Please ask for: Nicola Moore
Email: nicola.moore@arun.gov.uk
Telephone: Ext 37944
Our Ref: BR/131/21/HH
Your Ref:
Date: 11th May 2021

Application for Planning Permission for Works or Extension to a Dwelling

Development: Dropped kerb
Location: 78 Orchard Way Bognor Regis PO22 9HP

PROPOSED DROP KERB TO 78 ORCHARDWAY BOGNOR REGIS. PO22 9HP. FOR EXISTING DRIVE.

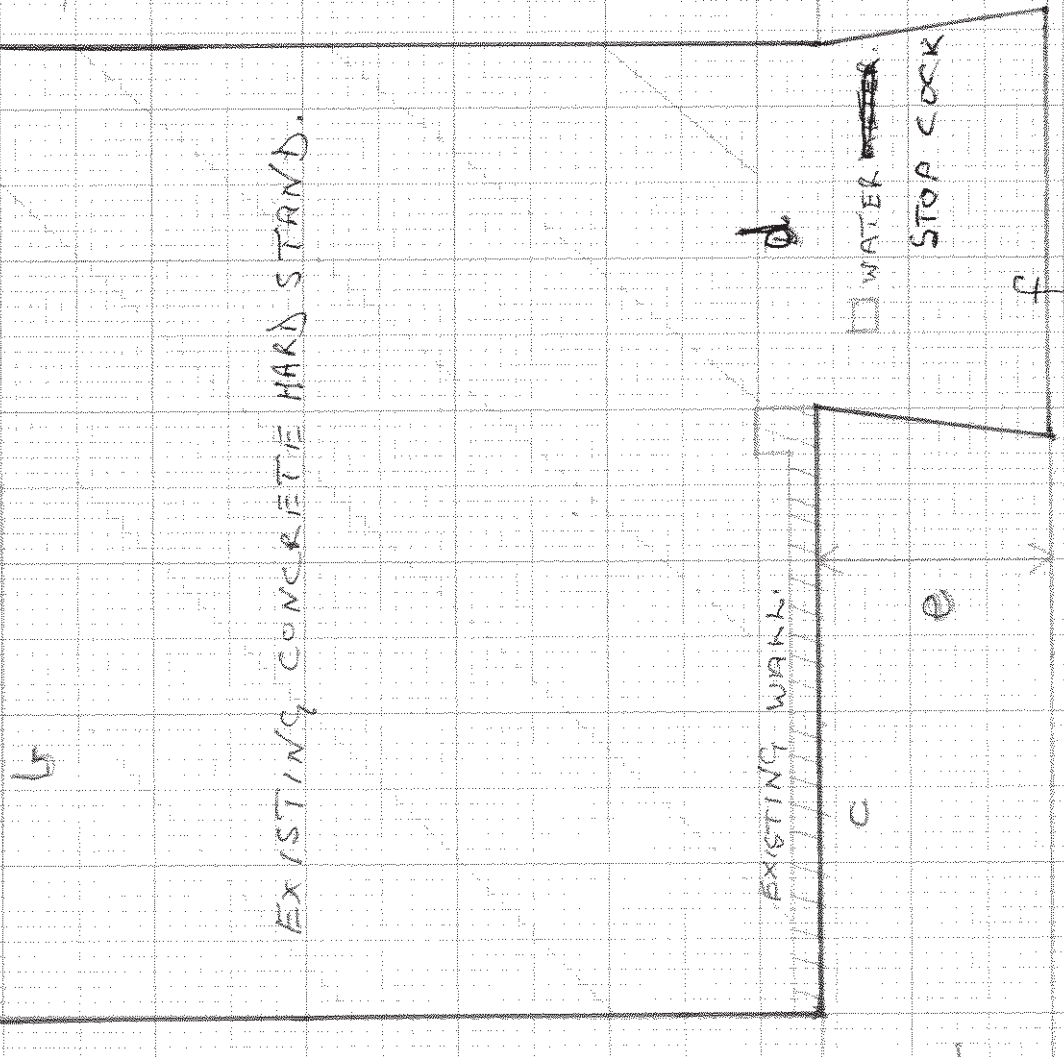
West Sussex County Council require that a visibility splay is provided. A splay is formed for a 30 mph speed limit road by measuring from a point 2.4m back from the kerb edge in the centre of the proposed access. A line should then be drawn from either side of this point for 43 m in each direction to the nearside edge of the carriage way. The splays must intersect and only within the control of the applicant, or within the publicly maintained highway.

The distance will increase with the speed limit of the road. If the road is 40 mph speed limit then the distance should be 120 m either side. For speeds above this please contact West Sussex County Council Highways for advice on what would be acceptable.
